Comment re: Staged redevelopment of the Saint Ignatius College Riverview School Campus and Stage 1 Works (SSD 7140)

APPROVED MASTERPLAN CONCEPT

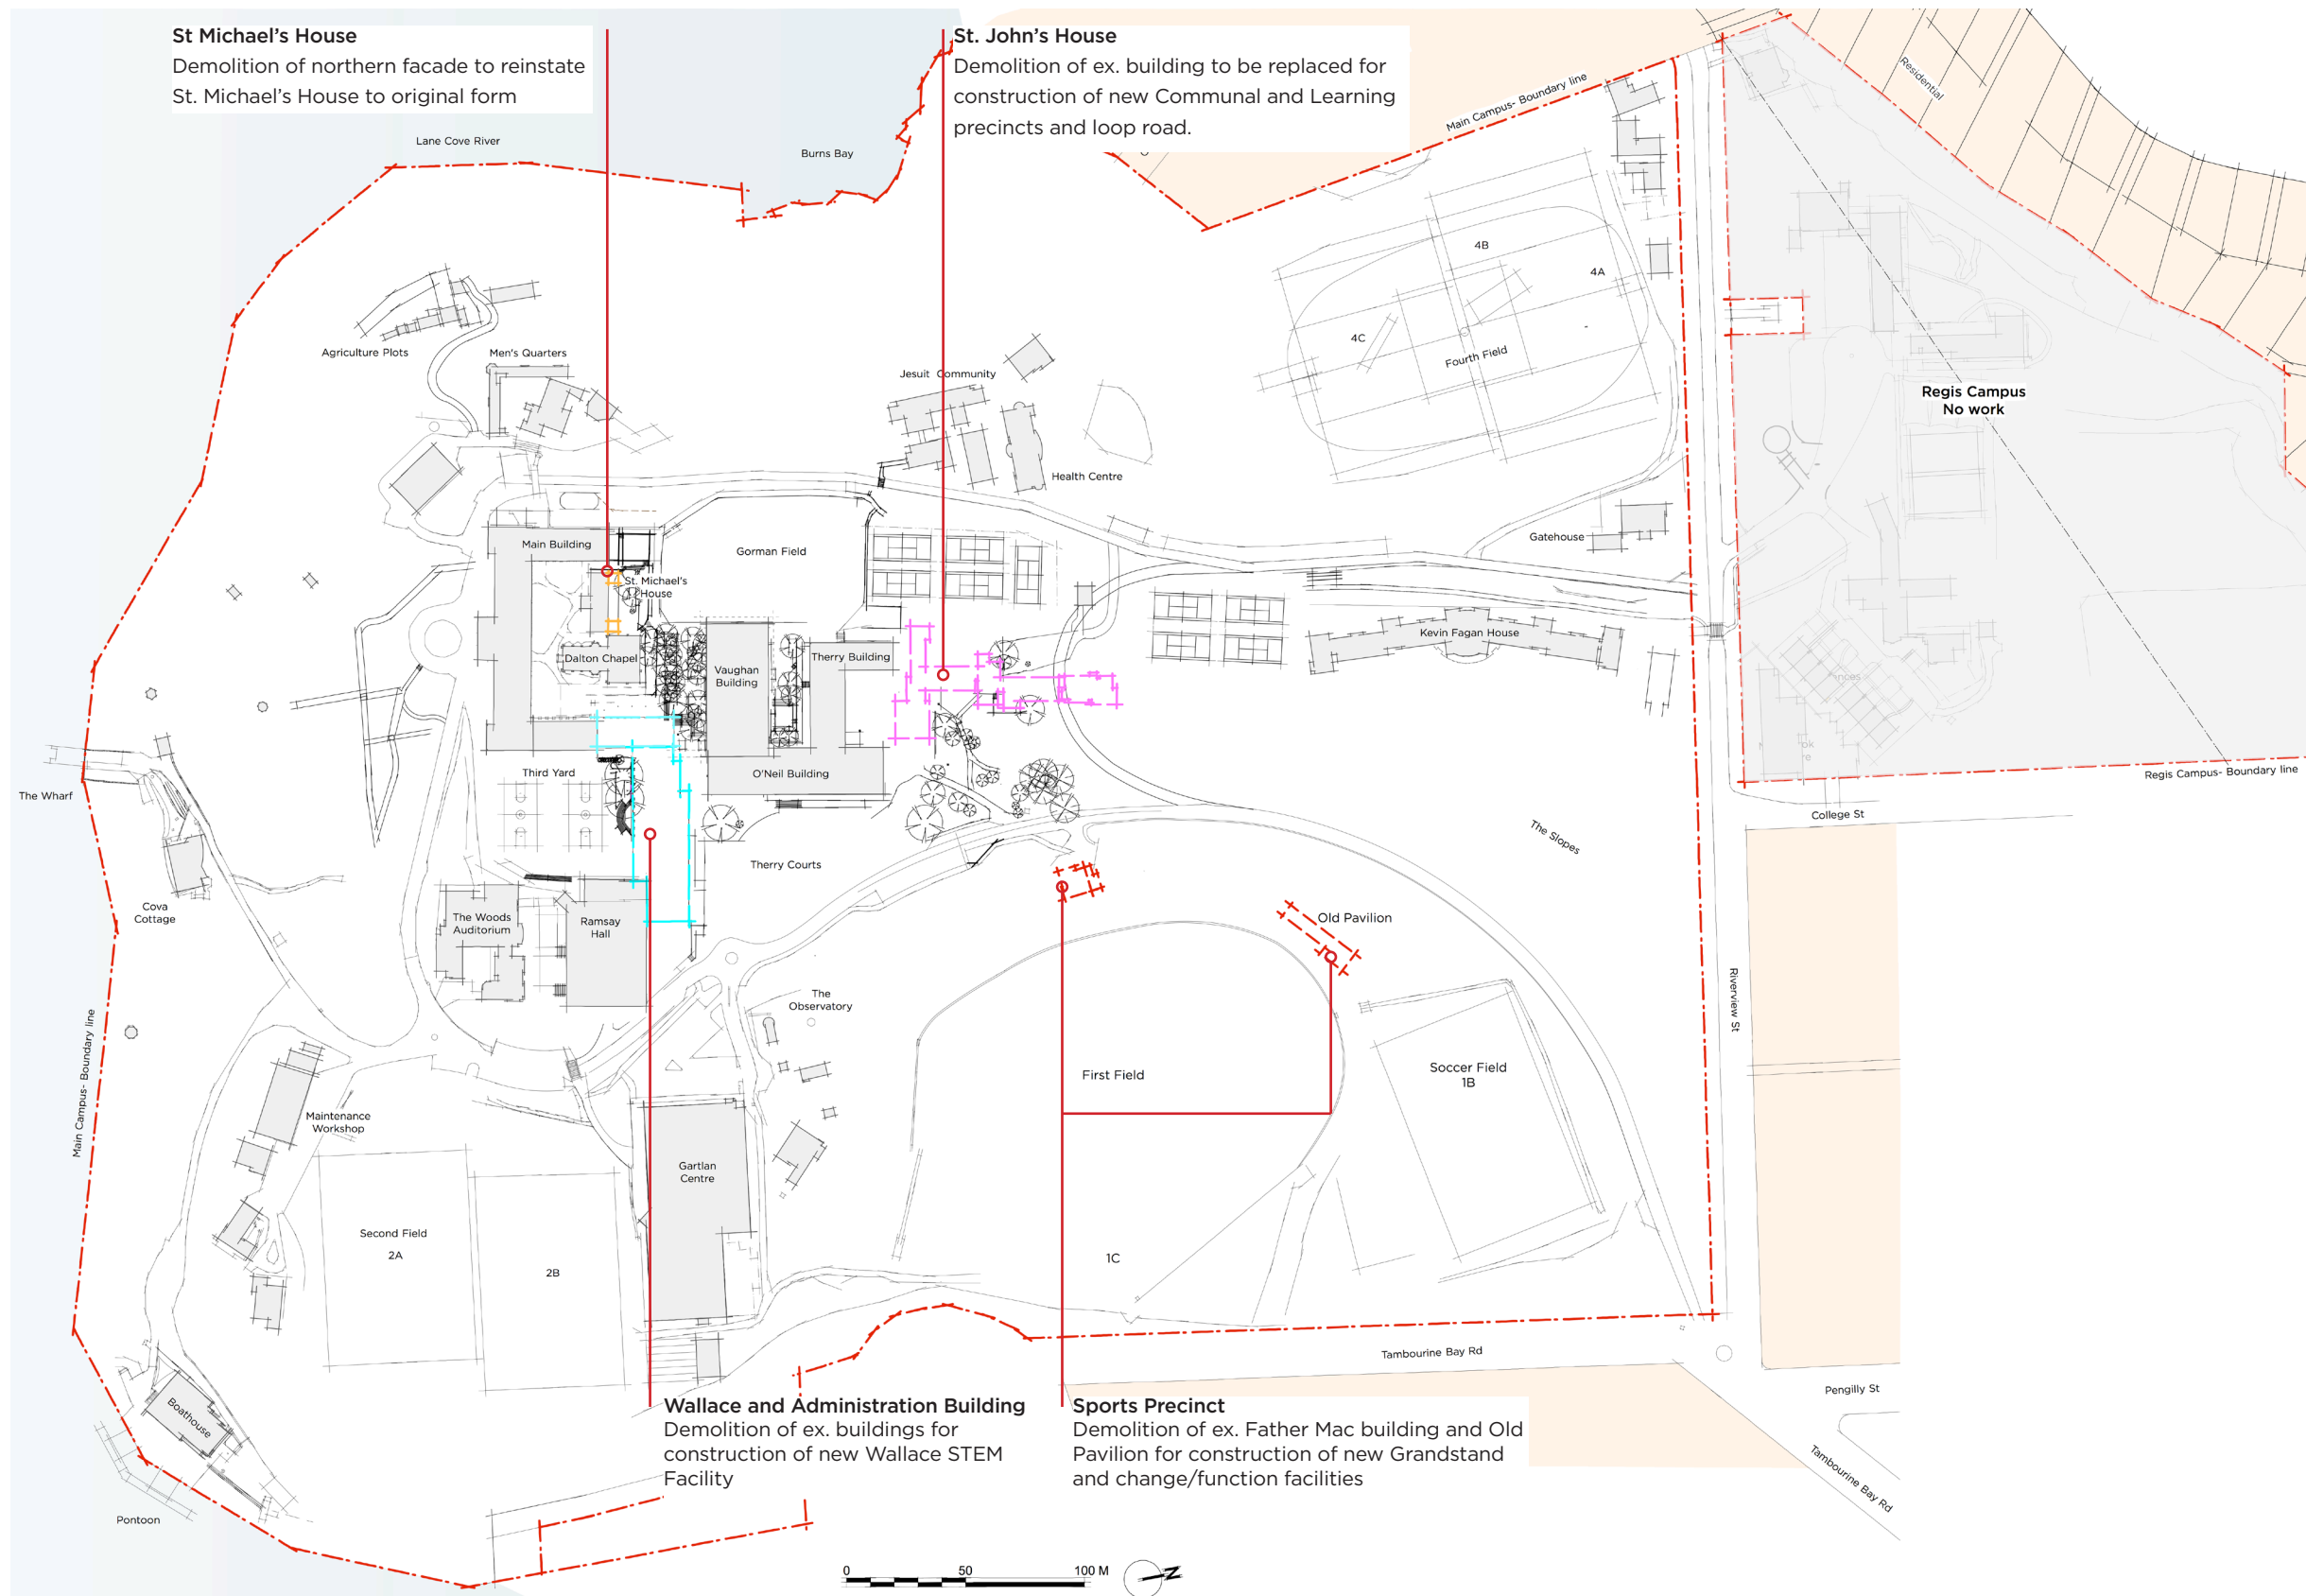
Whilst impressed with the Masterplan which will deliver a spectacular school precinct, advantageous not only to the school but also residents of Riverview, it is noticed there would appear to be an additional large amenities facility located opposite residential homes on the lower end of Tambourine Bay Road (shown on Proposed Site Concept Layout and Proposed Staging Plan of the St. Ignatius Riverview Masterplan.)

In perusing the Masterplan, there appears to be no reference anywhere in the documentation to this or details thereof concerning location, size, design or proposed use of such a facility on the Tambourine Road side of the Campus. (There is reference to the amenities facility in front of the Communal Precinct.)

In the light of absence of information on the building identified as "amenities" on the Proposed Site Concept Layout and Proposed Staging Plan, should a proposal for an additional facility be planned, and, given the scope of the school grounds, it would be appreciated if consideration could be given in the Planning stages to not locate such a building within close proximity to residents.
